PLANNING APPLICATION REPORT**REF NO:** **A/8/11/****LOCATION:** Avenals Farm
 Water Lane
 Angmering**PROPOSAL:** Conversion of barn/store into private residence for family members (re-submission of A/124/10/)**SITE AND SURROUNDINGS**

S.E. Elevation as proposed

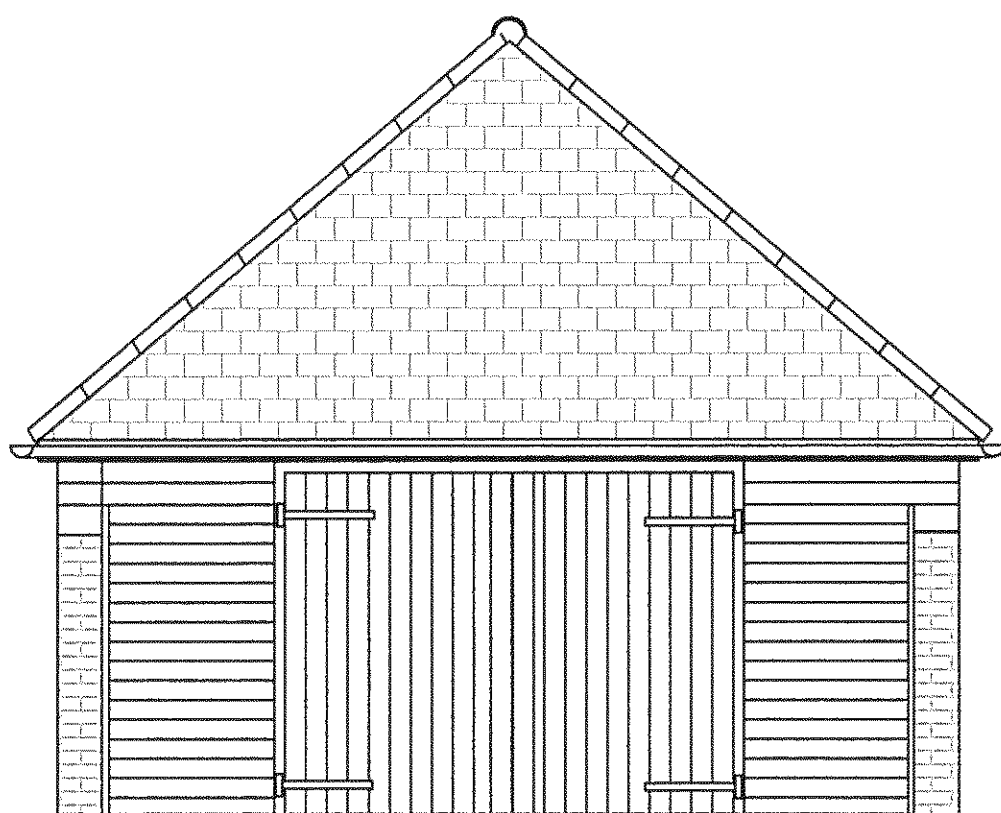
(iv) the resultant building is now appropriate in terms of its design. The proposed glazed opening in the south east elevation which was urban in appearance and out of keeping with the character of the existing building and the appearance of the countryside has been replaced with 2 windows and a door which are more in keeping with the appearance of the building and the rural setting.
